October 17, 2024

**RE: *McDonald's – Village at Lorson Ranch Filing No. 1 Lot 2***

## **COMMENT RESPONSE LETTER**

**ALLOWED SQ FT: 82.5**  
**PROPOSED SQ FT: 49.65**

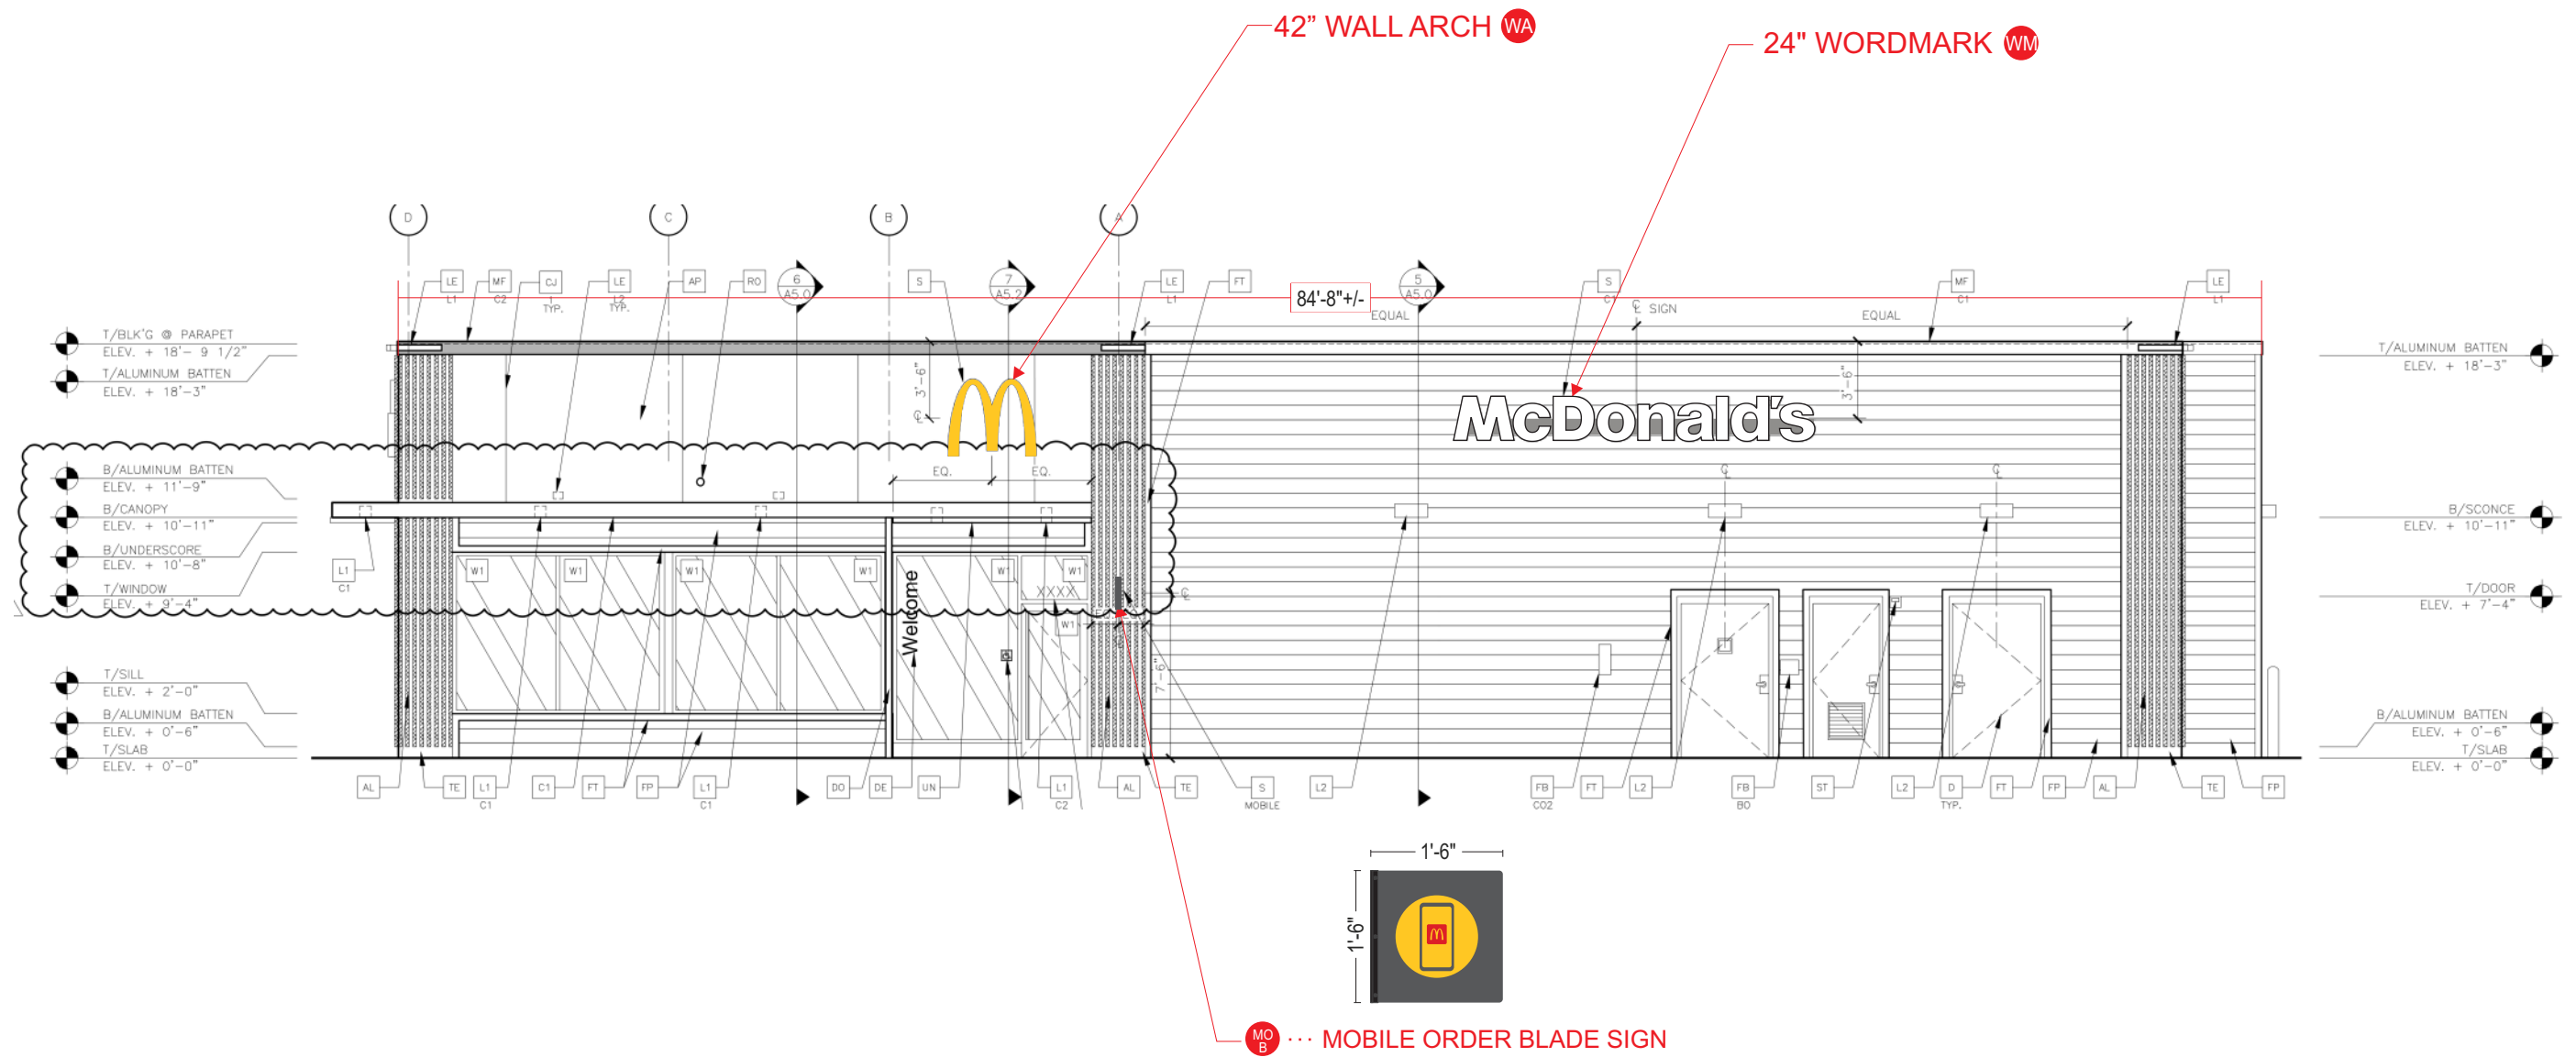
i. Please provide:

1. Summary of square footage of the total allowed signage and existing and proposed signage for the property.
2. Setback distances from all lot line to all existing and proposed signs.
3. Detailed description of illuminating devices and how the proposed illumination will be in compliance with the lighting standards.

■ **Response:** *Provided.*
